# ***City of Albuquerque***

**Re: Las Casitas del Rio Subdivision, Lots 2 and 3 Riverside Plaza, SIA/Financial  
Guarantee Release**

**Re: Las Casitas del Rio (Taylor Trust Townhomes) Grading & Drainage Plan  
Engineer's Stamp dated 12-18-01, (E12/D17)**

**Re: Las Casitas del Rio (Taylor Trust Townhomes) Grading & Drainage Plan  
Engineer's Stamp dated 10-1-01, (E12/D17)**

TITLE: LAS CASITAS DEL RIO SUBDIVISION
GRADING & DRAINAGE PLAN

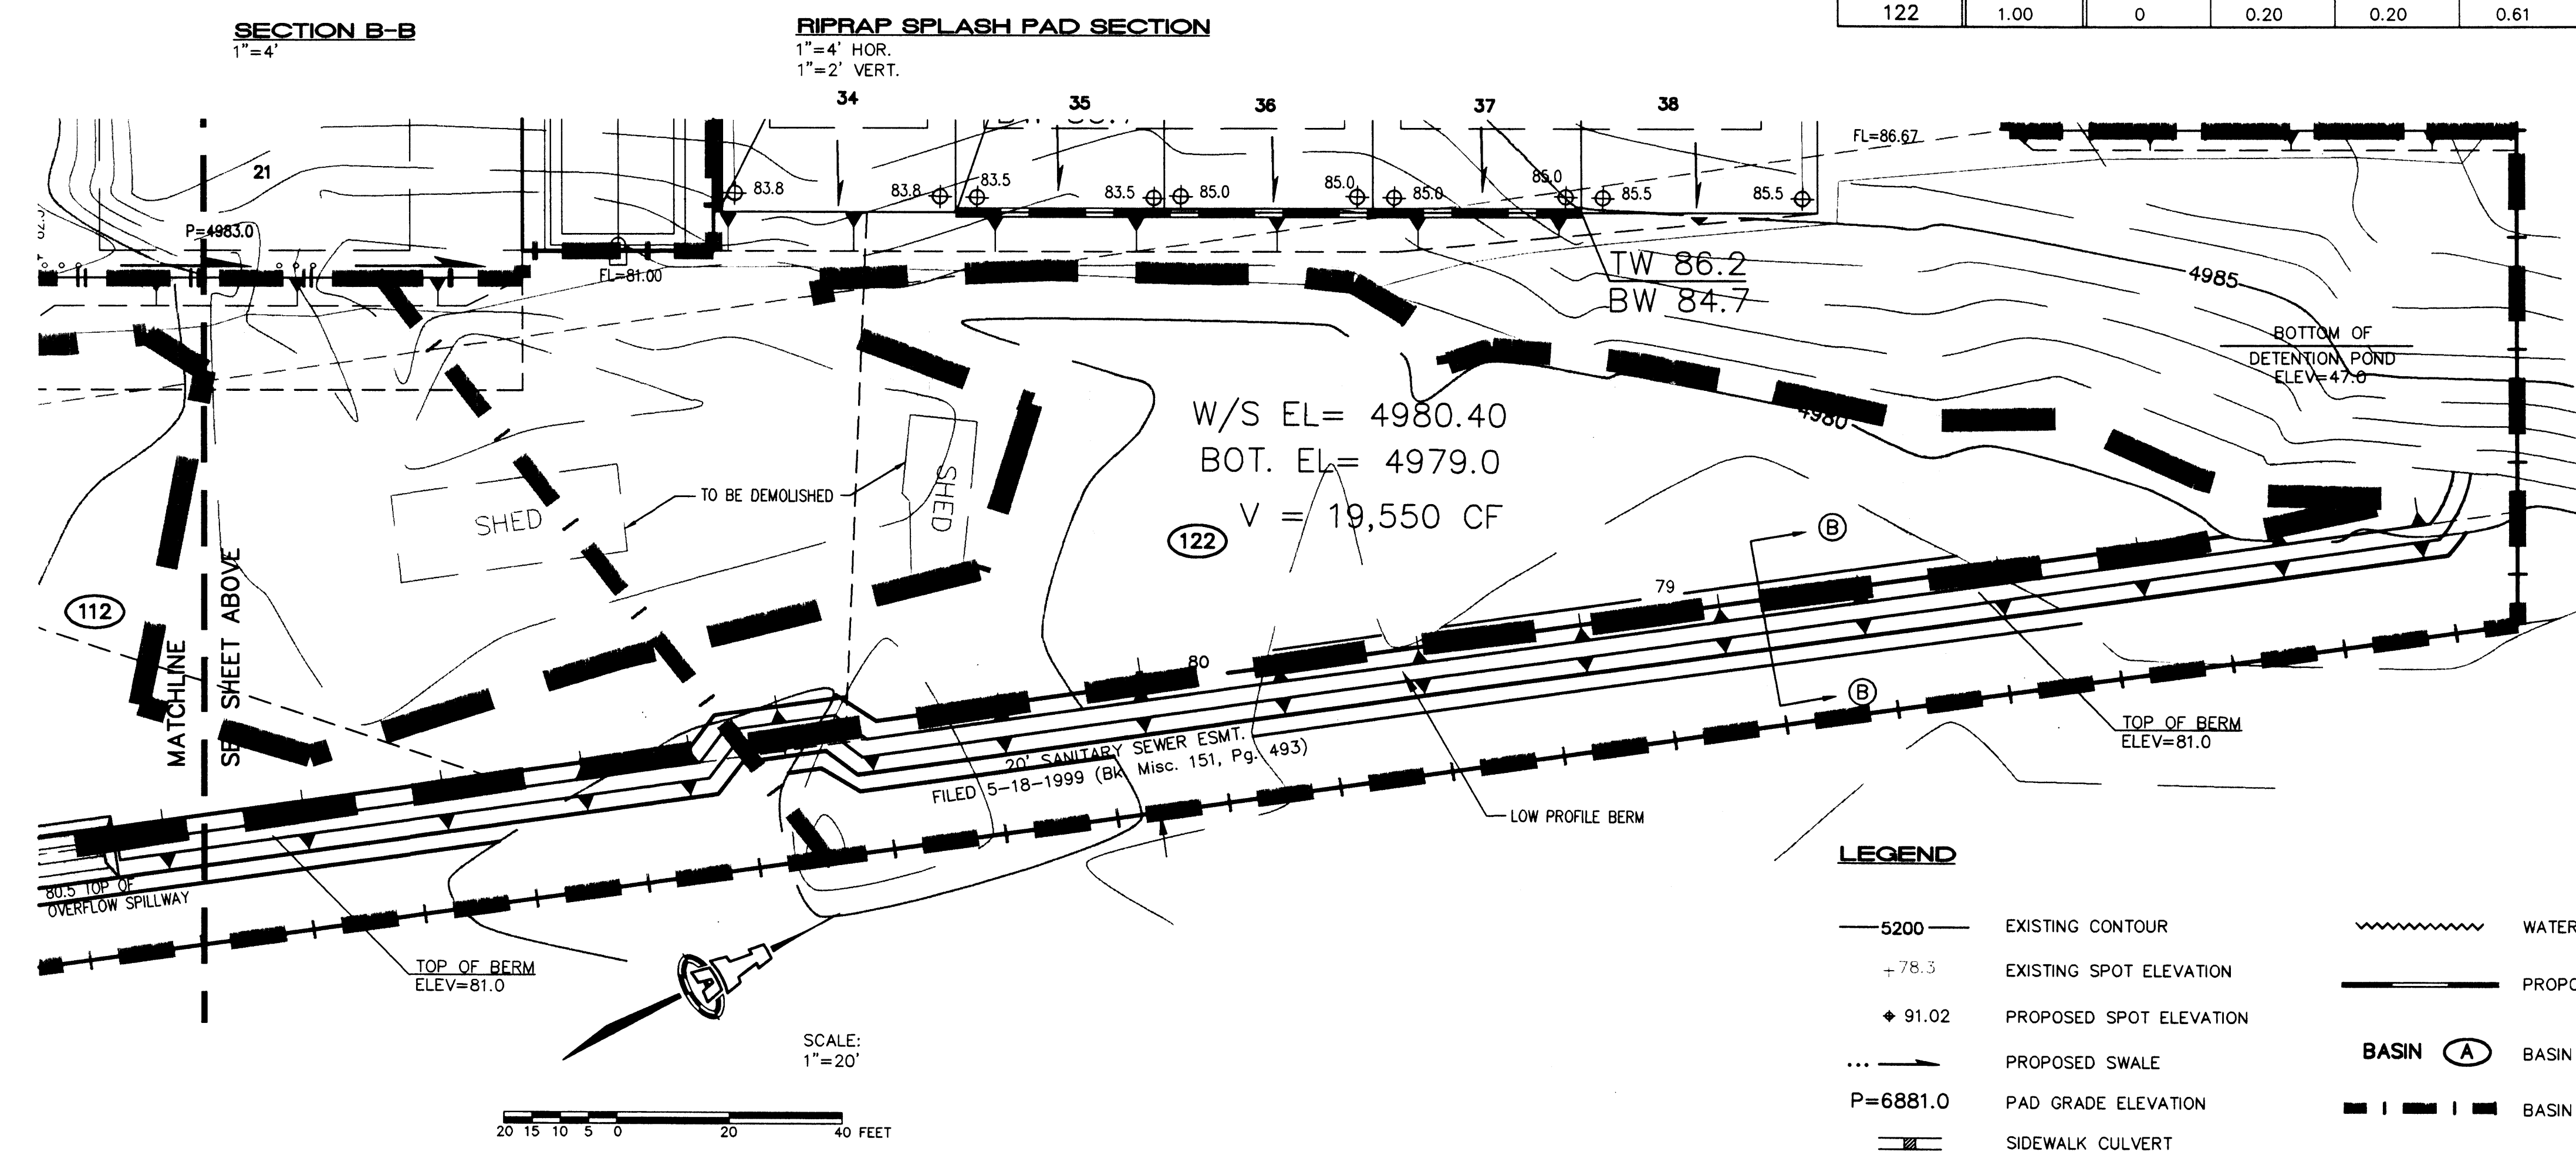
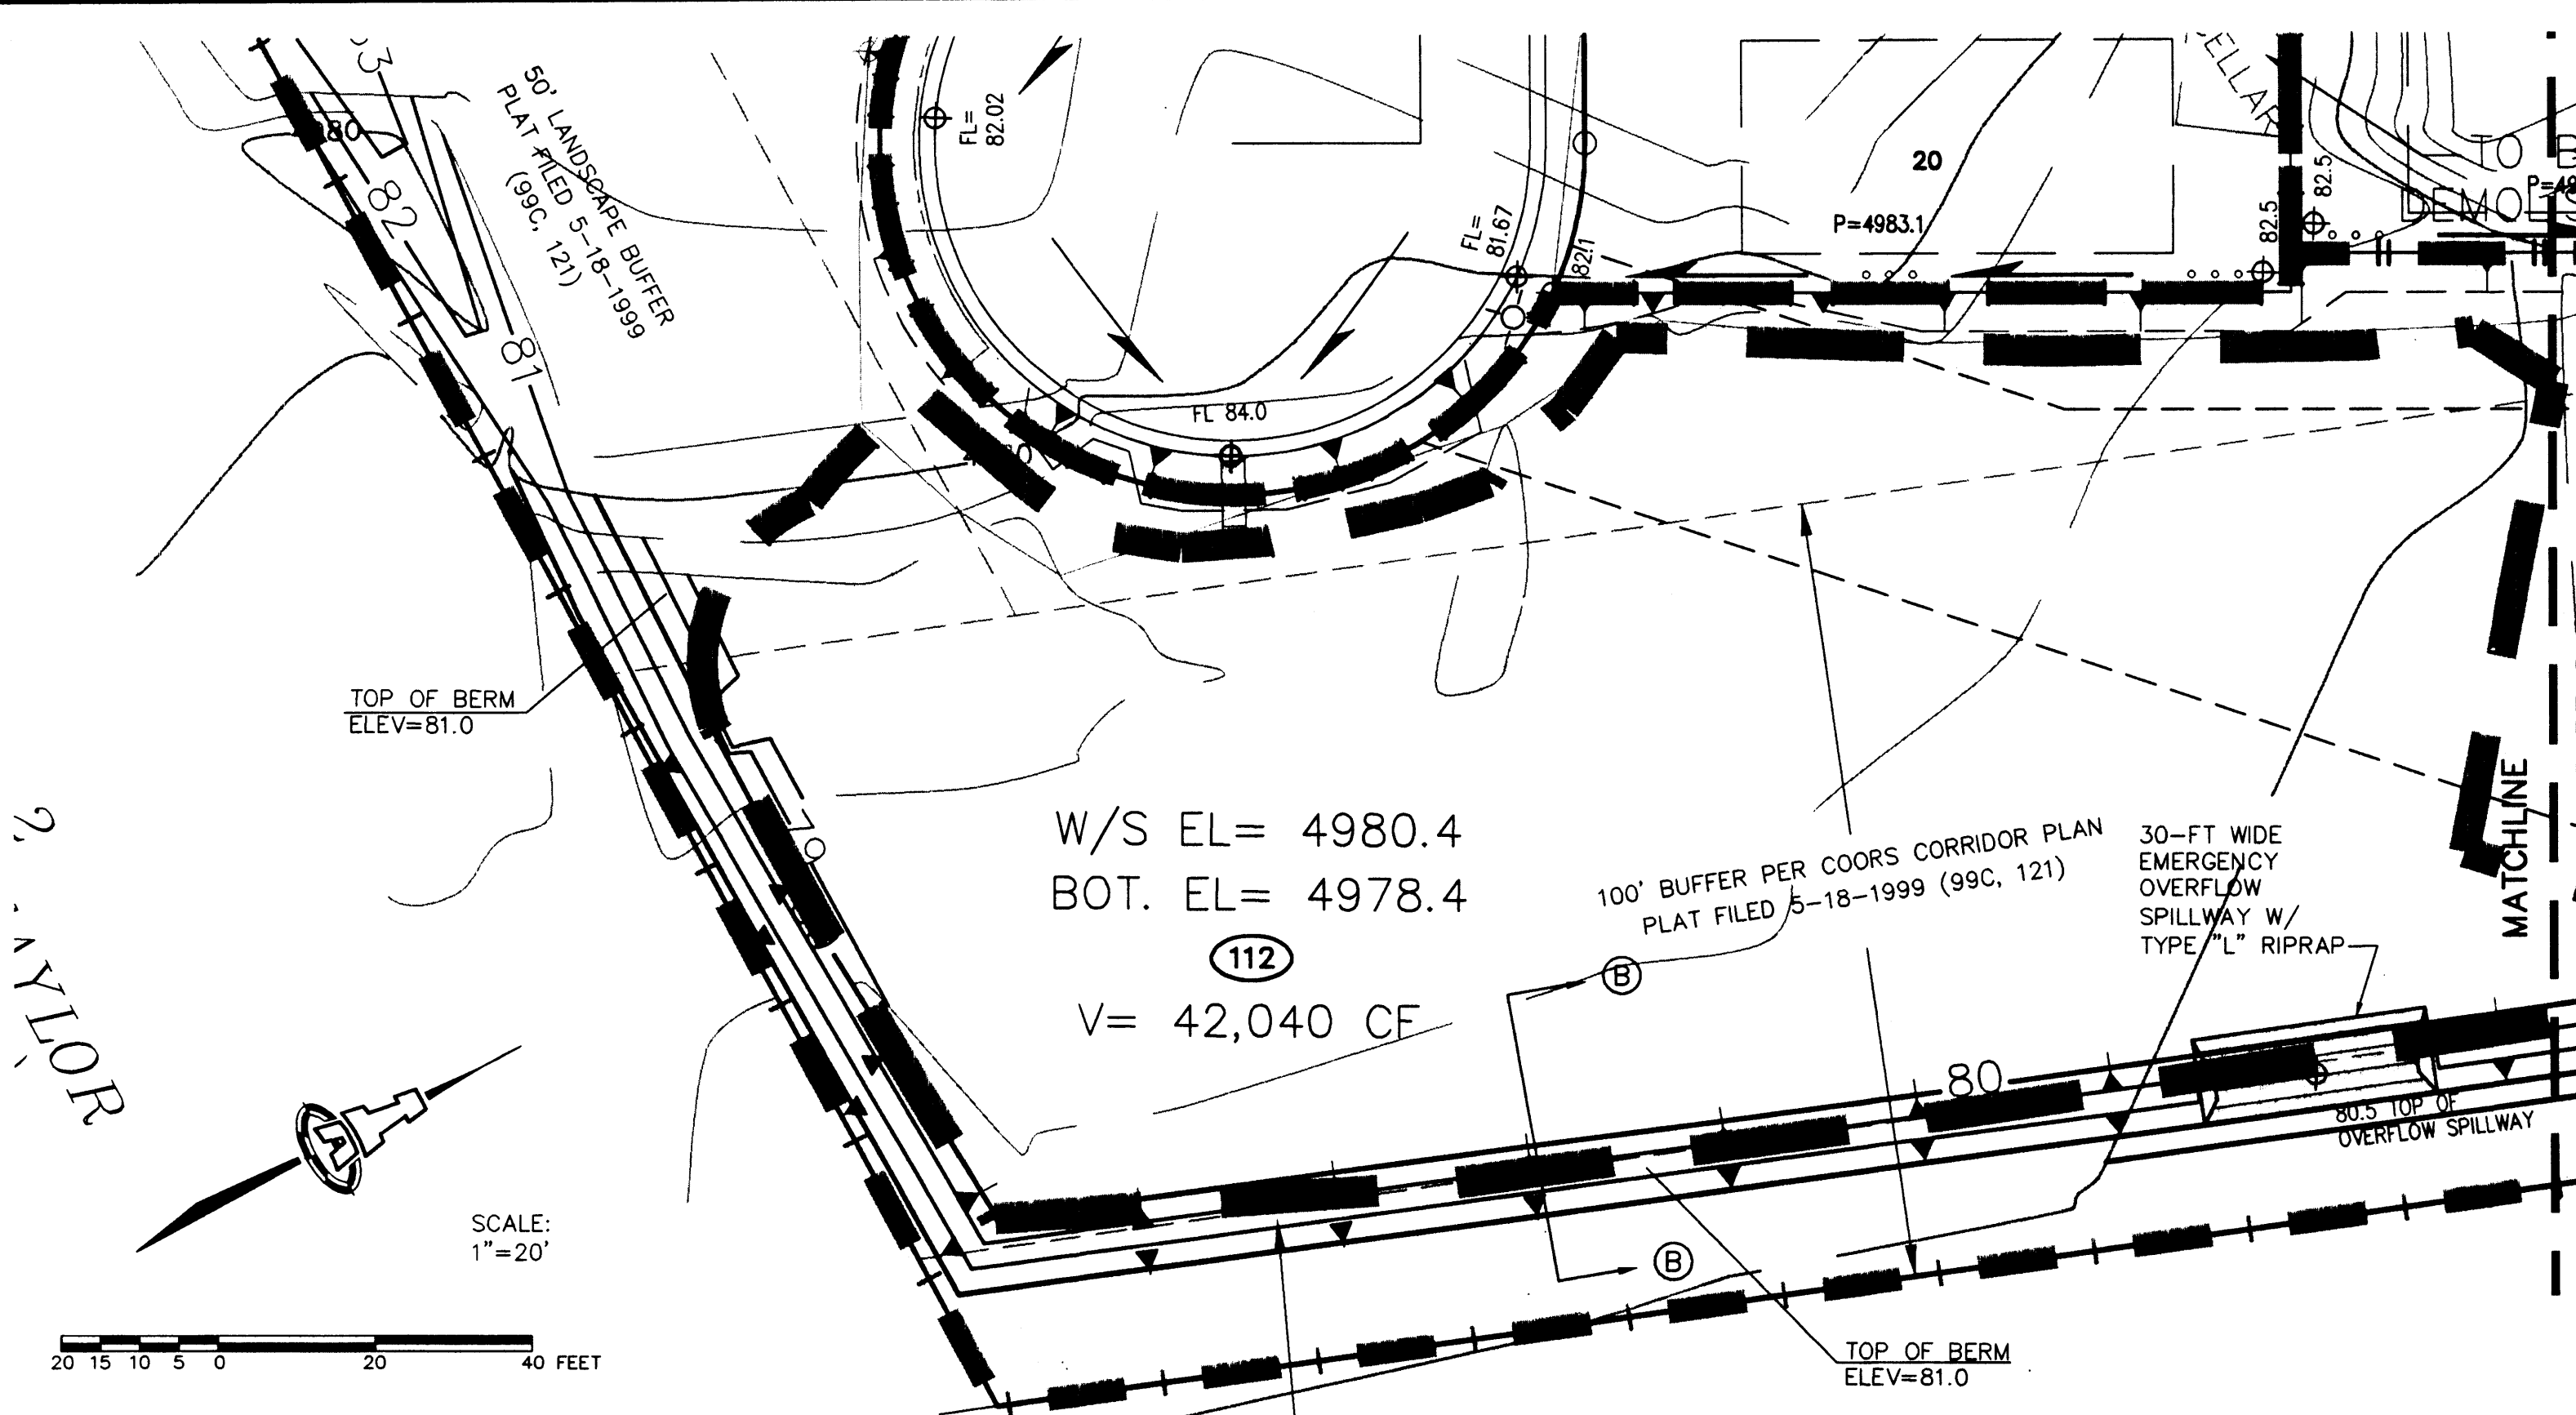
Based upon the information provided in your submittal dated 10-2-01, the above referenced plan is approved for Site Plan for Building Permit and Site Plan for Subdivision and Preliminary Plat. Please denote the size of the retention pond and include a provision for agreement and covenant. The ponding area will need to be in a public easement.
